Comments Re: Planning Application A/79/21/DOC Dappers Lane Angmering

I am writing with reference to the above application to discharge Condition Nos: 6 & 27, the requirement for a CEMP to be submitted for approval.

Appendix A
Construction Access Map

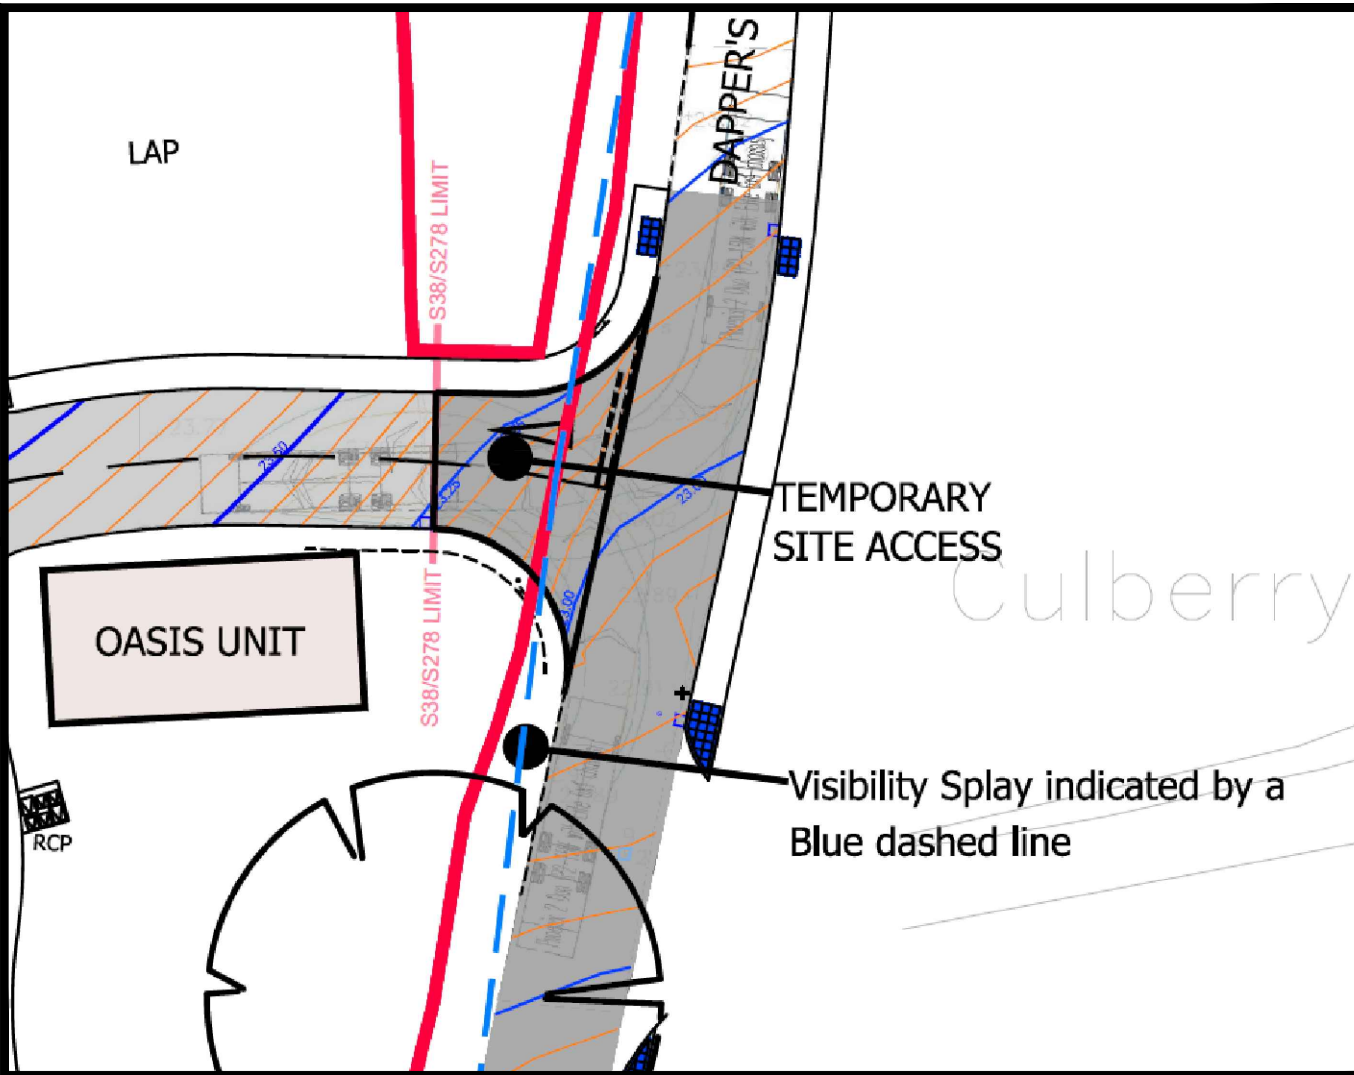
The method of access and routing of vehicles. The description provided is of insufficient detail and should include maps and instructions. E.g., ...

The route to the site will be from the A280 and Water Lane. Vehicles arriving from the north via the A27 will join the A280 then turn right into Water Lane then turn right again into Dappers Lane.

Vehicles arriving from the south via the A259 will join the A280 northbound turning left into Water Lane then right into Dappers Lane.

No vehicle is to access the site from the south via Station Road passing through Angmering village centre.

No traffic is to access the site from the north, Dappers Lane is one way only at the top.

All vehicles leaving the site are to turn left and continue north up Dappers Lane passing through the underpass before re-joining the A27 and A280 at the Titnore roundabouts. To return to the A259 they continue down the A280 Angmering Bypass.

The routes to and from the site are indicated on Appendix 1.

The provision of wheel washing facilities. The provision of the wheel washing facilities as described should be extended to include the employment of a dedicated worker to operate the equipment ensuring every vehicle leaving the site complies and does not deposit material on the local public highway. Road sweeping to be carried out on a regular timetable, every Friday afternoon.
